## EL PASO COUNTY GRADING AND EROSION CONTROL PLAN CHECKLIST

EPC Project Number: **PPR2440**

**TABLE SB-1, SIZING INFORMATION FOR STANDARD SEDIMENT BASIN**

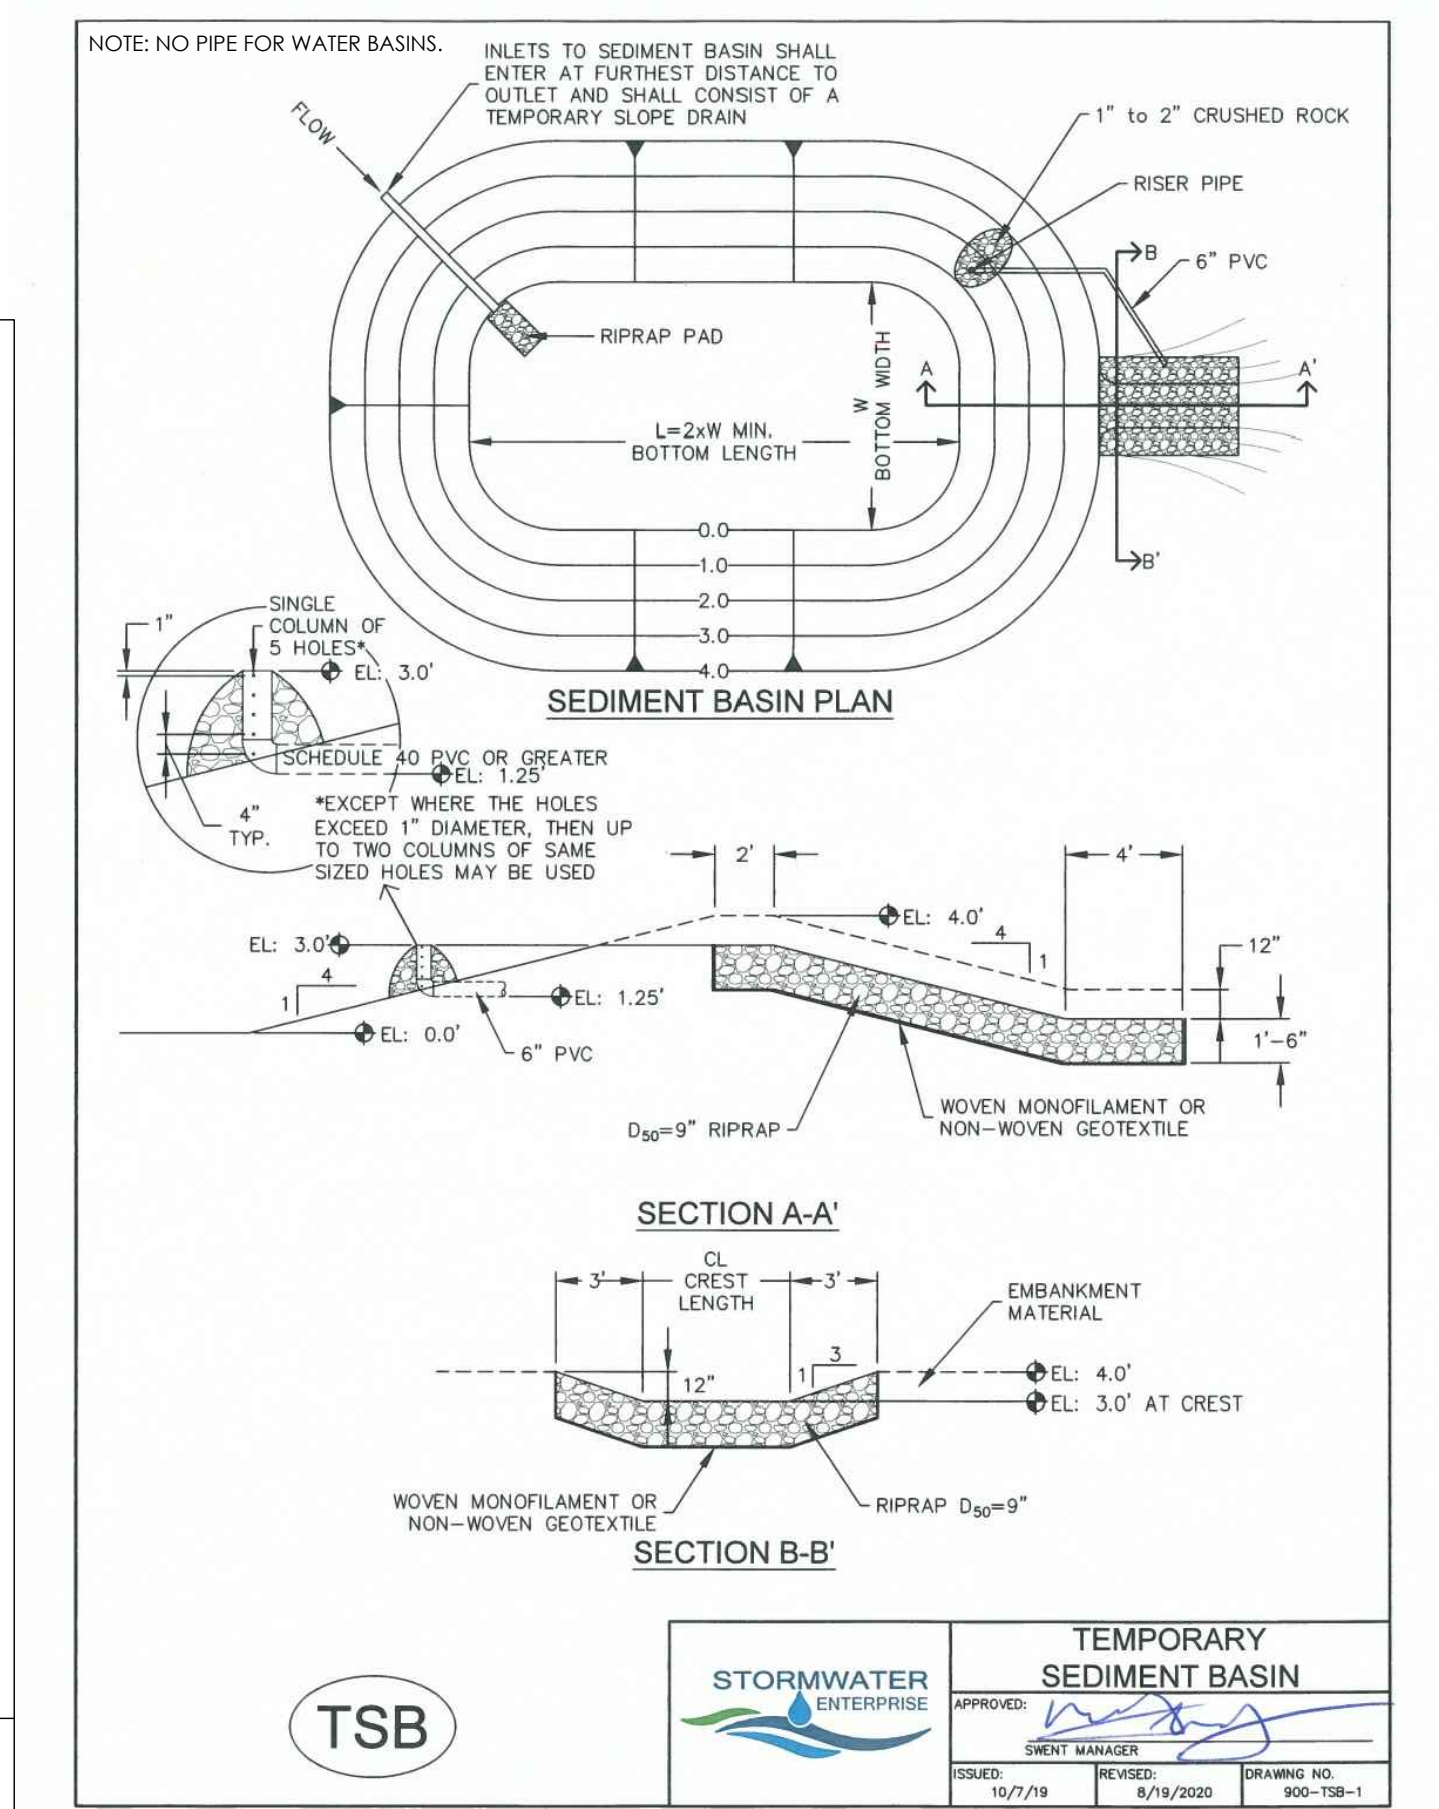
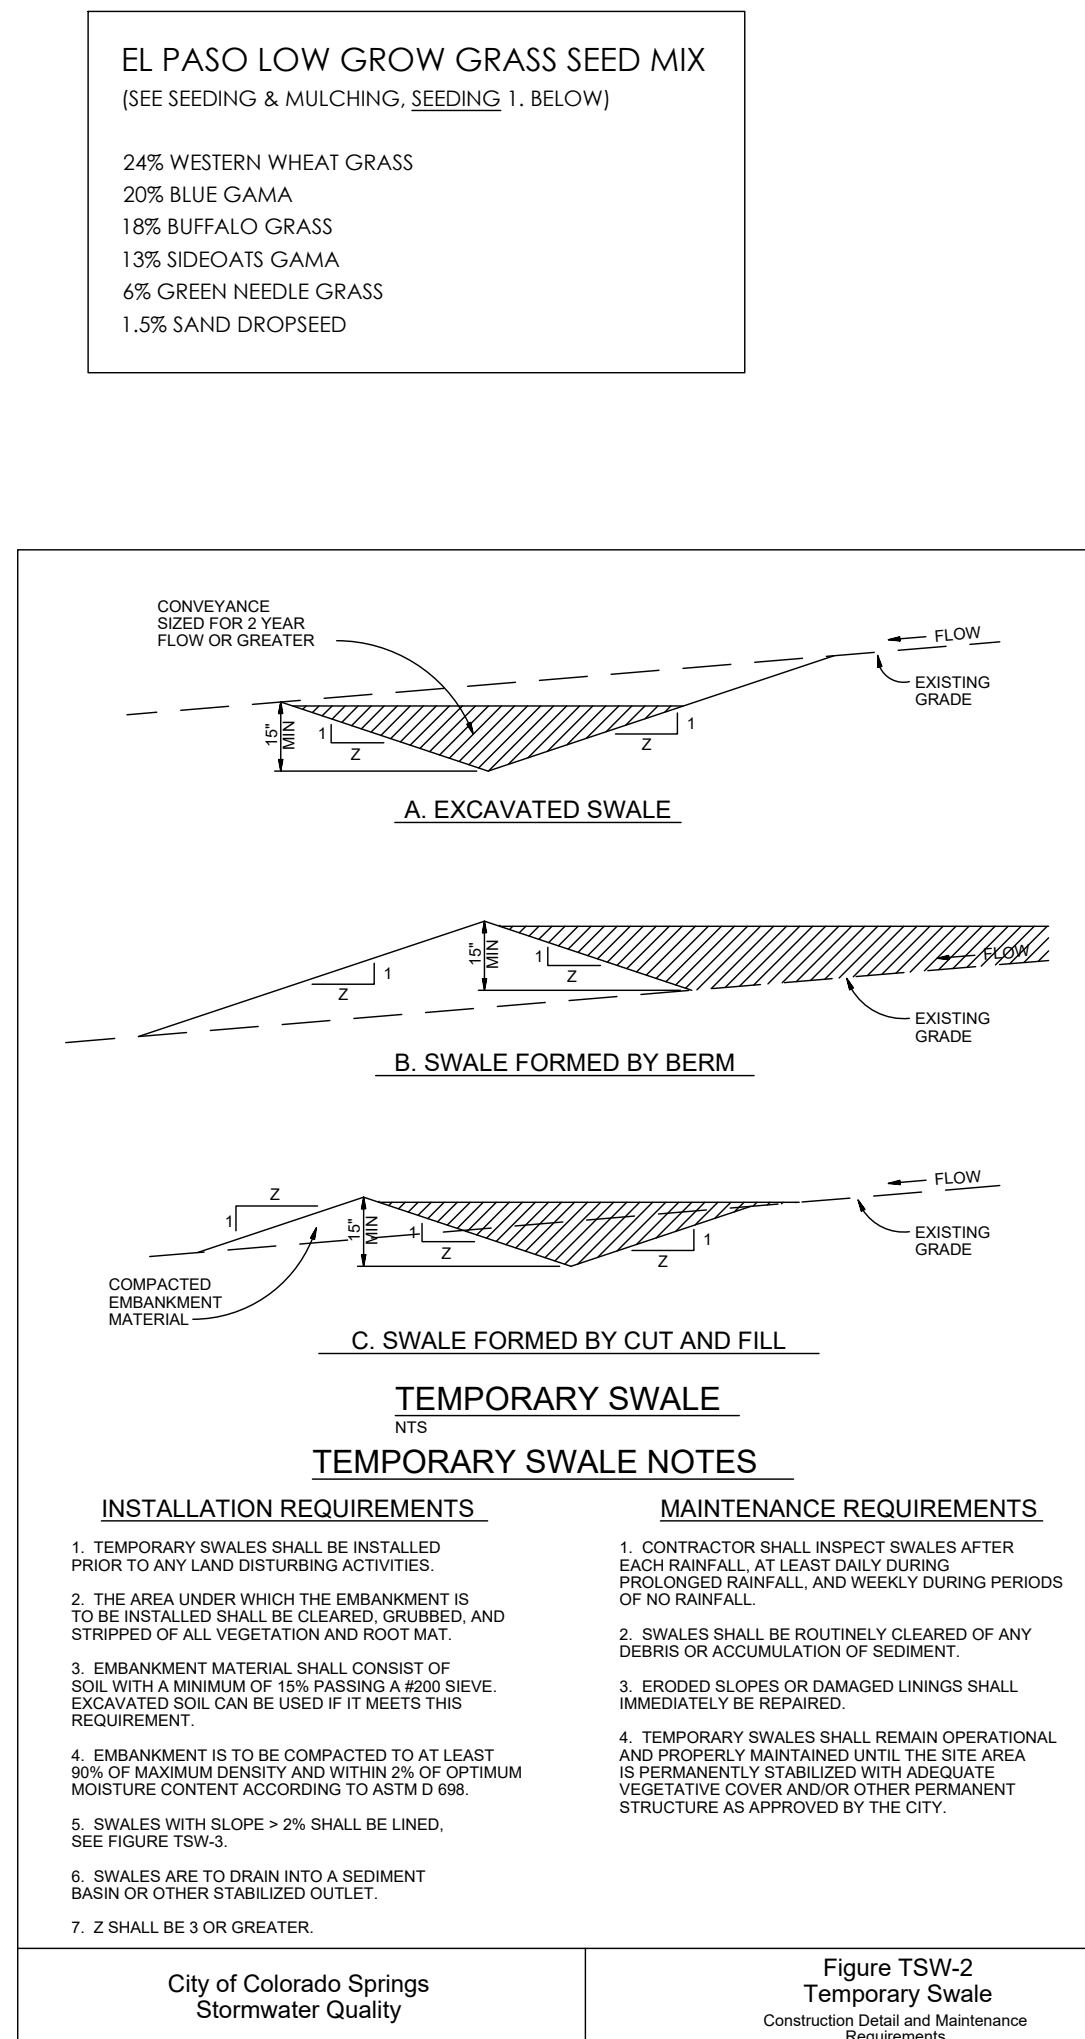
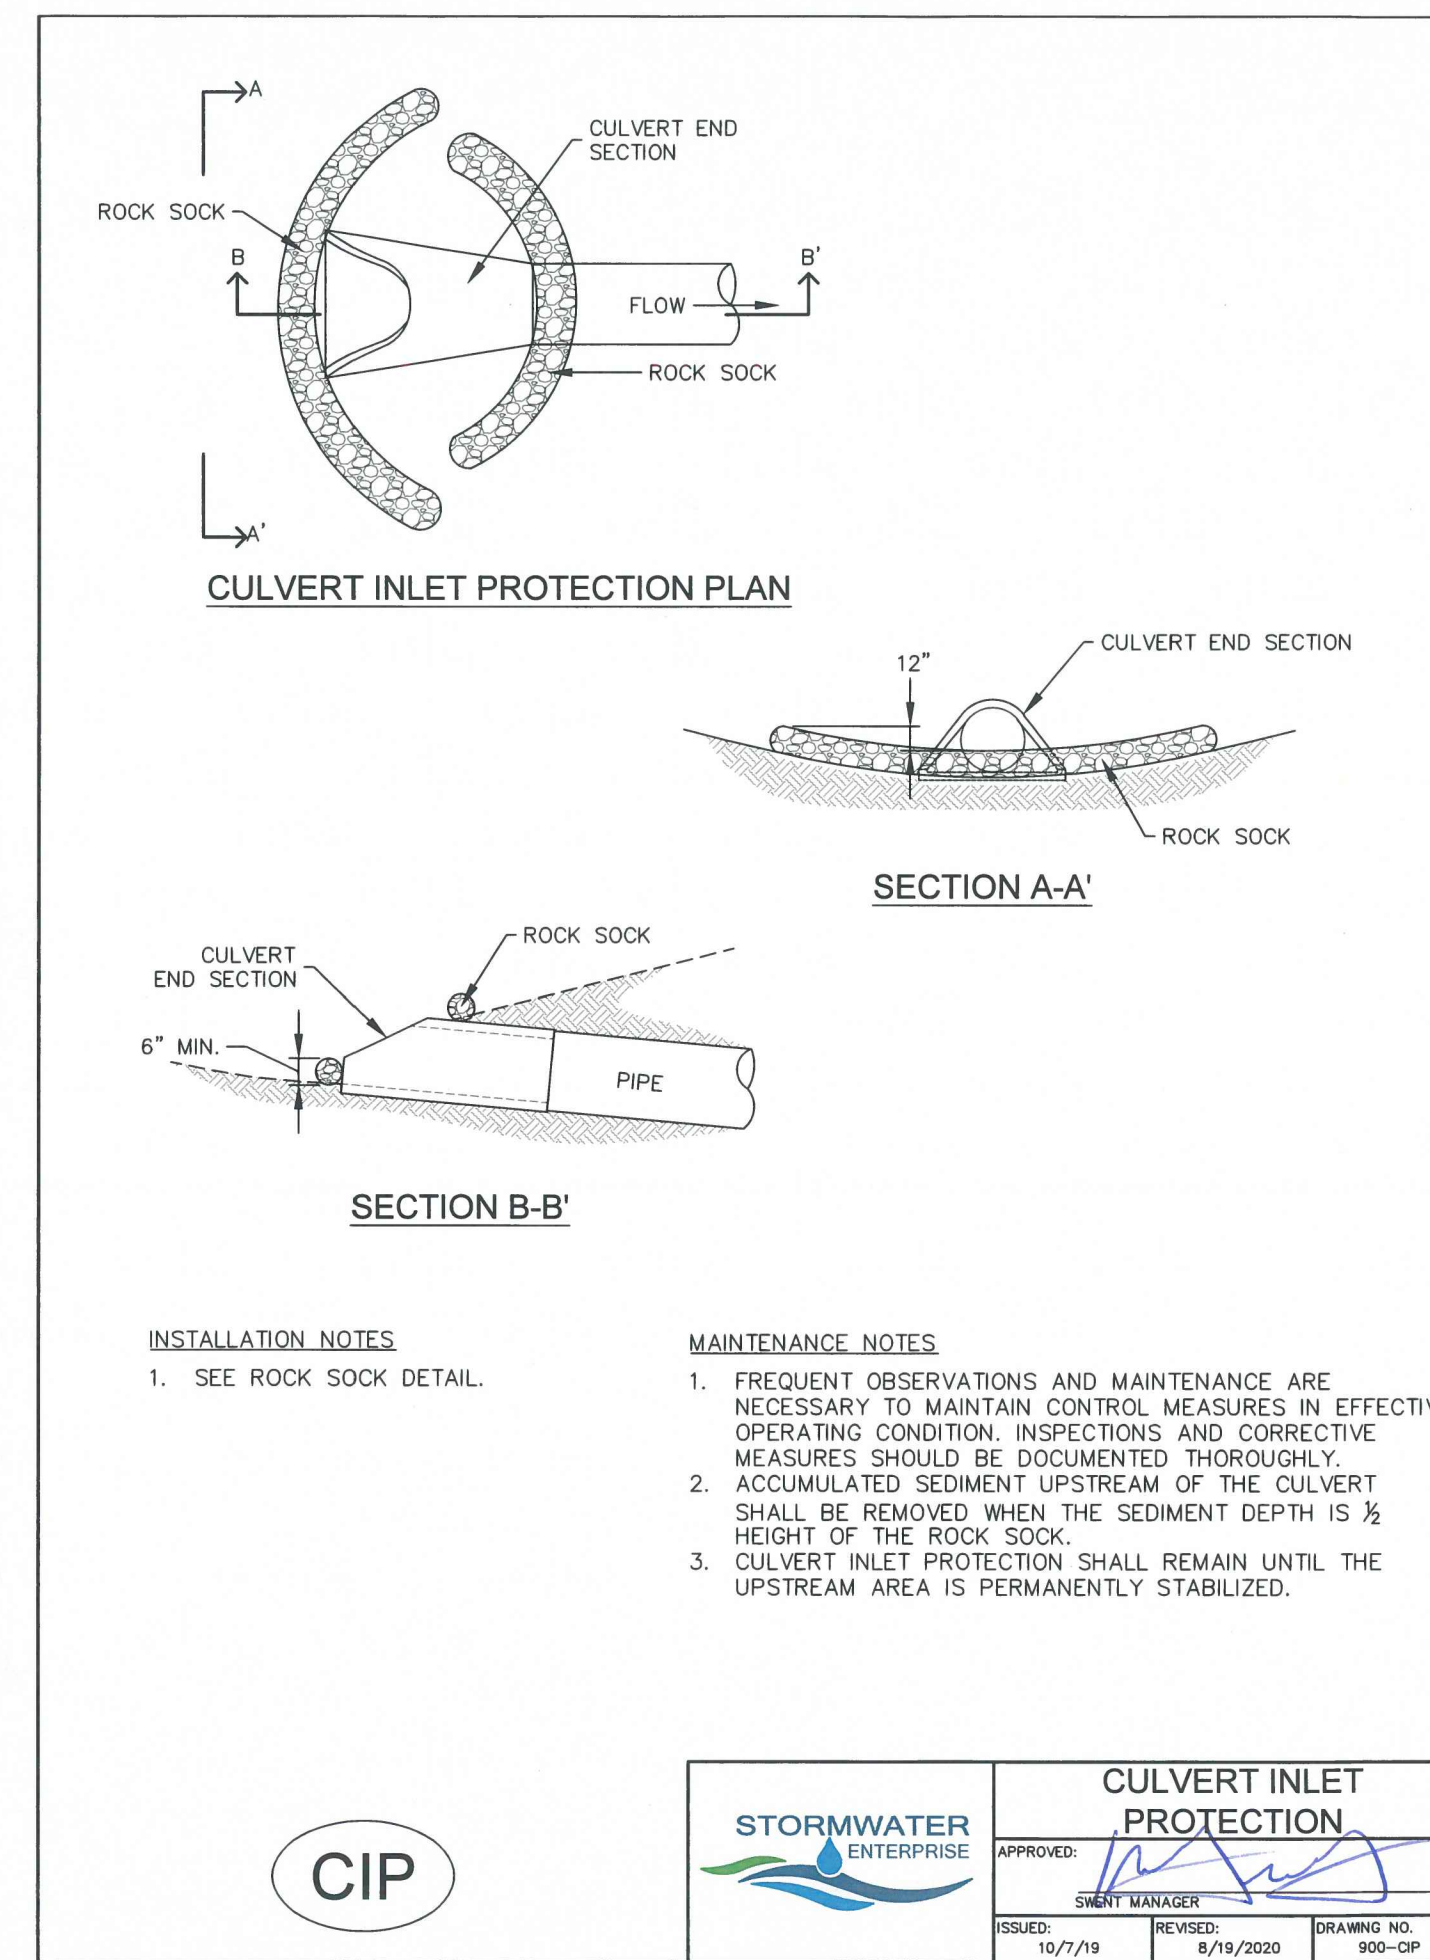
v	All proposed temporary construction control measures, structural and non-structural. Temporary construction control measures shall be identified by phase of implementation to include "initial," "interim," and "final" or shown on separate phased maps identifying each phase		Y
w	Vehicle tracking provided at all construction entrances/exits. Construction fencing, barricades, and/or signage provided at access points not to be used for construction		Y
x	<b>Temporary sediment ponds provided for disturbed drainage areas greater than 1 acre</b>		N
